Your ref: 3/2025/0095

Application 3/2025/0095: Proposed erection of a part single-storey and part two-storey dwelling of exceptional design quality (NPPF 84e) with associated landscaping, habitat restoration, change of use of land to residential curtilage and access from Higher Road, together with the creation of a small visitor car park for members of the public to view the remains of the Roman road to be preserved (if feasible) within the site.

Land at Higher Road, Longridge PR3 2YX

Peter Iles
Planning Officer (Archaeology),
Historic Environment Team

Proposed Site Plan

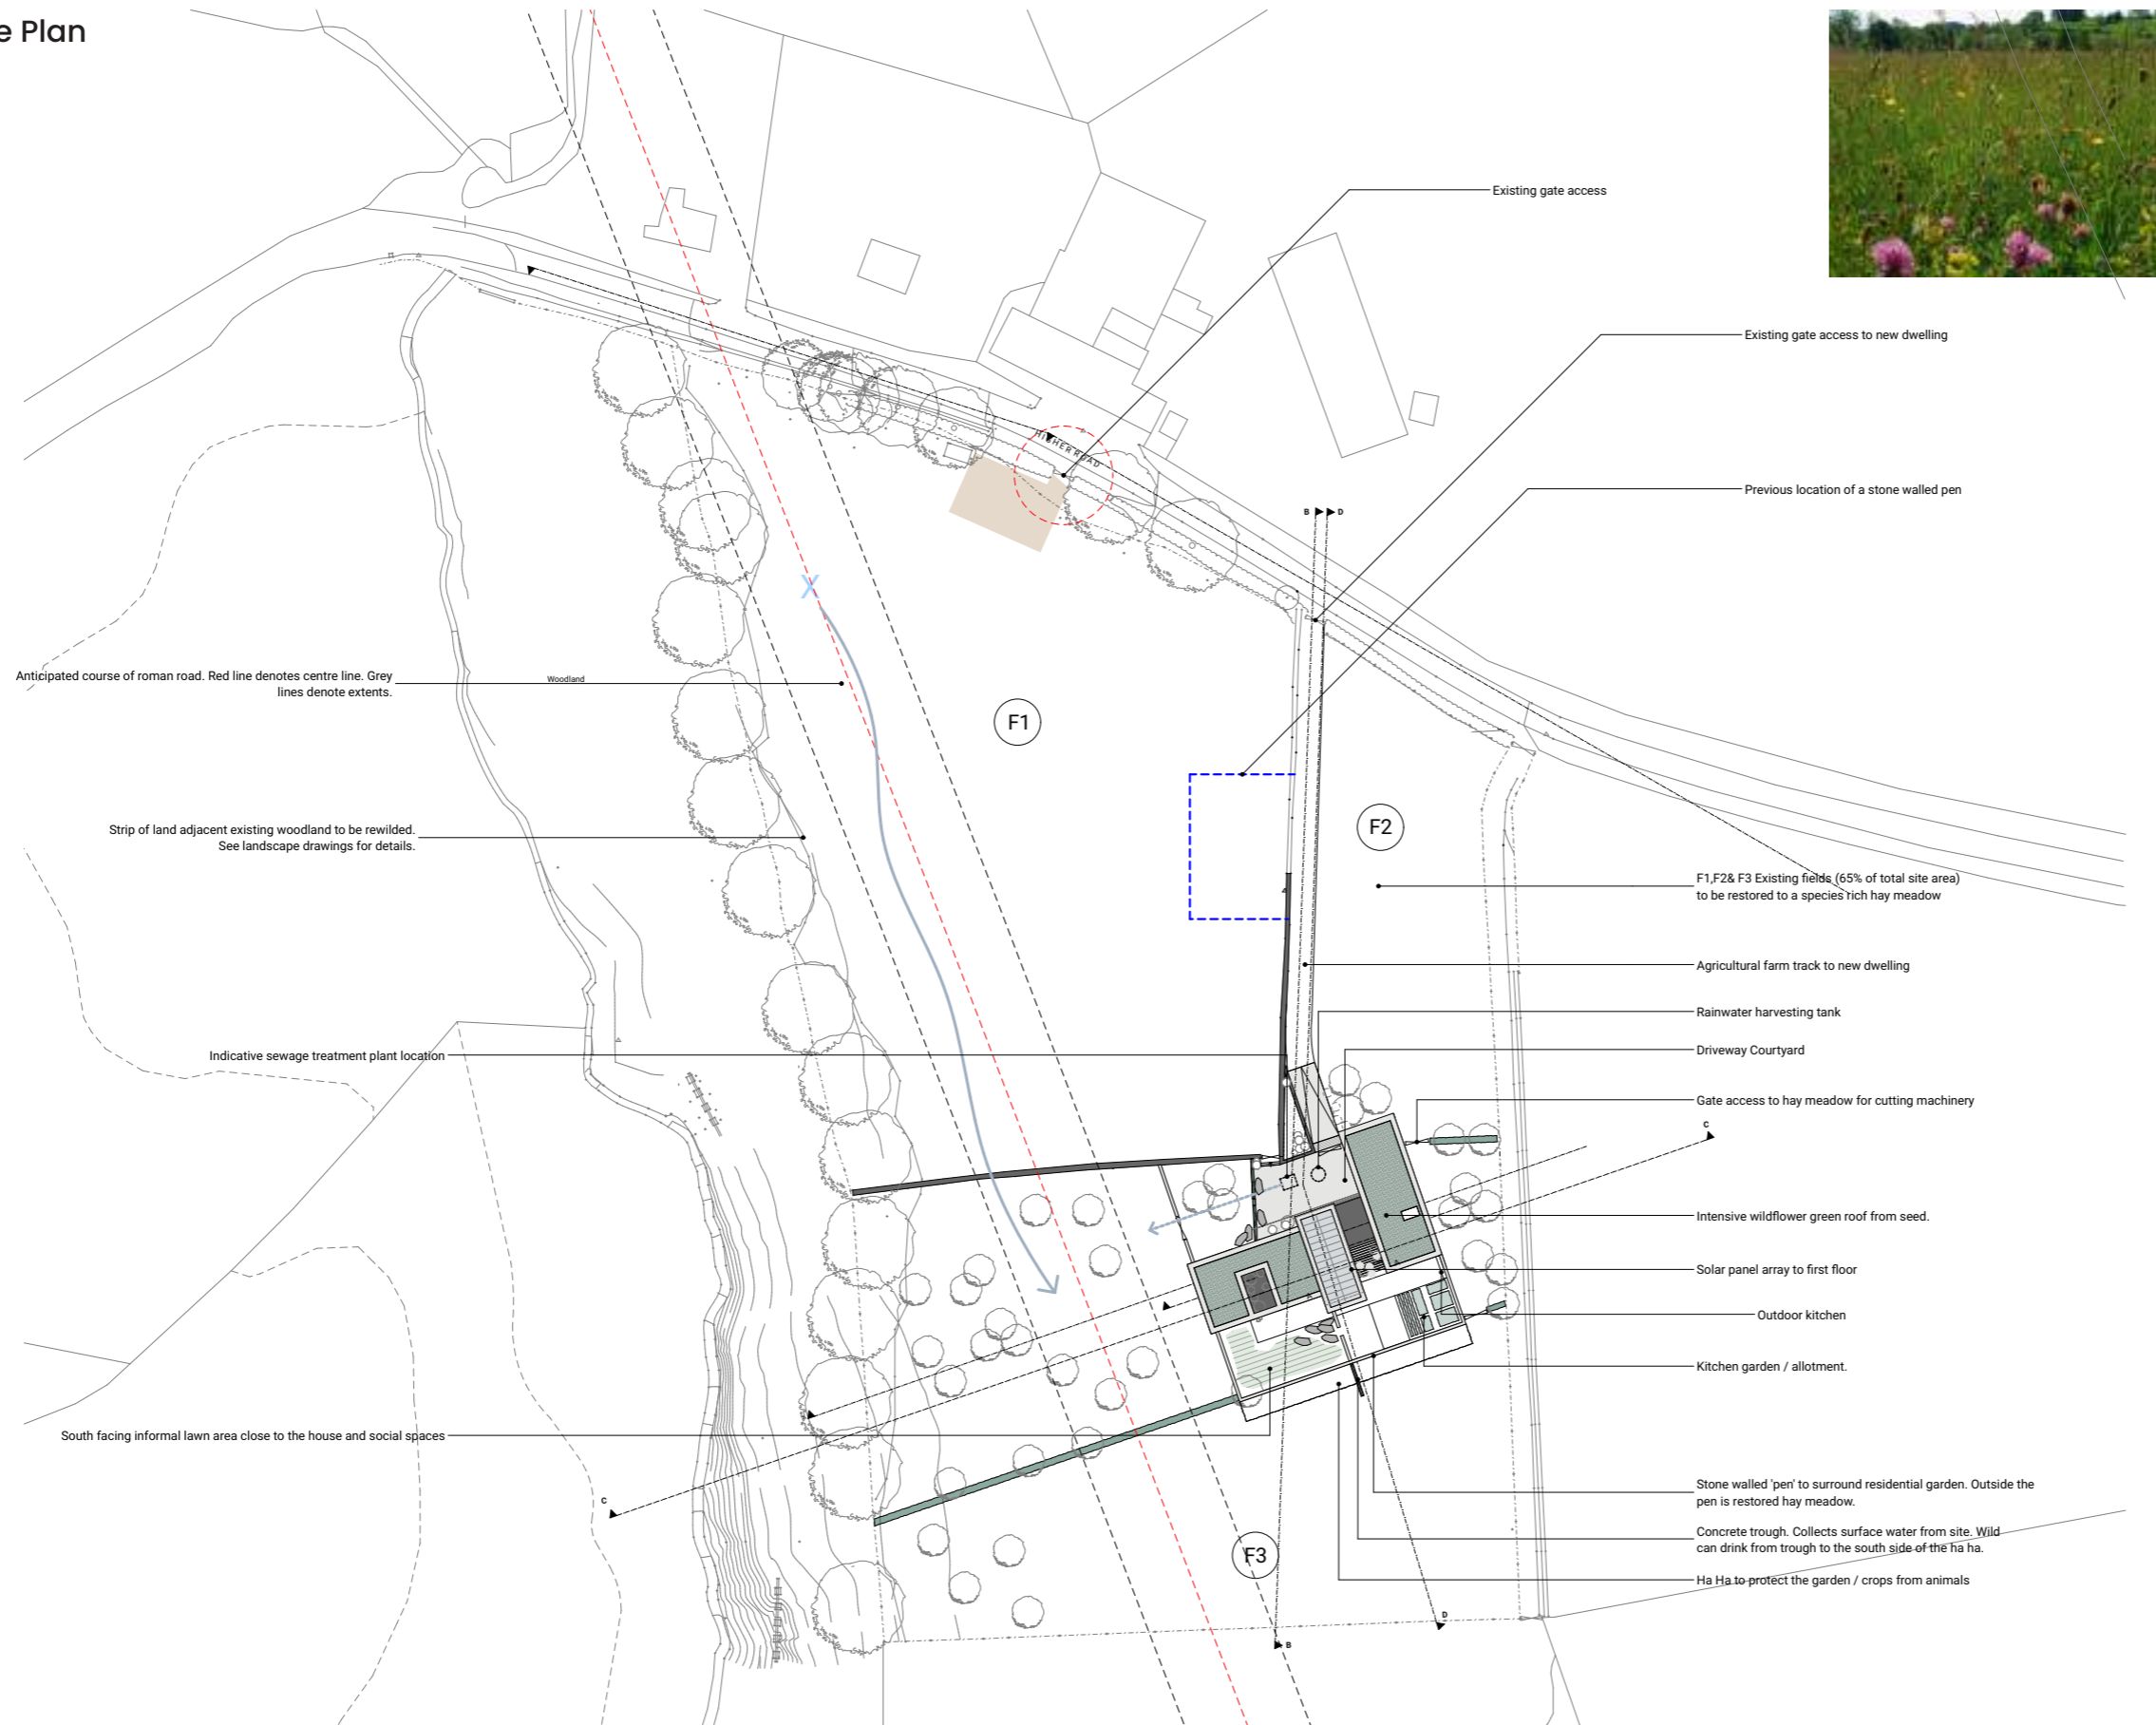
The water pipe ran just to the west of and parallel to the extant agricultural track, then crossed the line of the Roman road immediately south of the proposed development area. Our records also suggest that the pipe runs under the west wing of the proposed new house and the applicants should urgently contact United Utilities to check on this. The following assumes that the pipeline can be avoided by the construction works or can be diverted under/around the proposed dwelling and also avoid the Roman road. If this is not likely to be the case, we would like to be re-consulted and given the opportunity to provide comments on any altered or adapted scheme.

We note the care that has been taken to avoid placing the proposed new dwelling on the line of the Roman road, as well as the possible roadside quarry identified to the west of the road. As stated in section 5 of the DBA the only known remains that would be impacted by the present plans are post medieval trackways and possible ridge and furrow, although there is still a potential for as-yet unknown buried remains to be affected. There is no indication that any such remains would be of national importance and thus merit preservation at the expense of development, but precautionary archaeological works will still be necessary. We would agree with the DBA (section 5.2) however that these can be required by a planning condition rather than some or all being undertaken prior to determination. We would recommend that these include (i) the erection of a physical barrier on the site to protect the line of the Roman road in the form of well-anchored Herras fencing, chestnut paling or similar, to prohibit access and accidental rutting or damage to the remains of the road; and (ii) a programme of 'strip, map and record' works within (a) the house plot, and (b) any site compounds, bunds, material stores, temporary parking areas, etc., required for the works. Service runs, including any diversion of existing services, should avoid the fenced-off area of the Roman road, but if this cannot be avoided then these should also be subject to the 'strip, map and record' scheme. The depth of stripping should be sufficient to allow the construction works to proceed or to a depth which shows that no buried remains exist, whichever is the shallower.

Landscape or agricultural works to restore the surrounding hay meadows or 'restore/rewild' the landscape in the immediate vicinity of the Roman road should not include anything that would potentially damage the remains of the road. The planting of trees, shrubs etc. should avoid the identified road corridor and not allow or encourage root spread into or 'scrubbing up' of the road corridor.

Condition: No excavation or ground disturbance works on the application site, including any required for clearance/demolition, site preparation, compounds, services, landscaping, etc. shall take place until the applicant, or their agent or successors in title, has secured the implementation of a programme of archaeological works, to the standards and guidance set out by the Chartered Institute for Archaeologists as an integral part of the groundworks required for the development. The works should include:

- (i) An appropriate method of fencing off and protecting the Roman road corridor; and
- (ii) A programme of 'strip, map and record' across the house plot, any site compounds, bunds, material stores, temporary parking areas, etc., required for the works.

- (iii) Service runs, including any diversion of existing services, should avoid the fenced-off area of the Roman road, but if this cannot be avoided then these should also be subject to the 'strip, map and record' scheme.
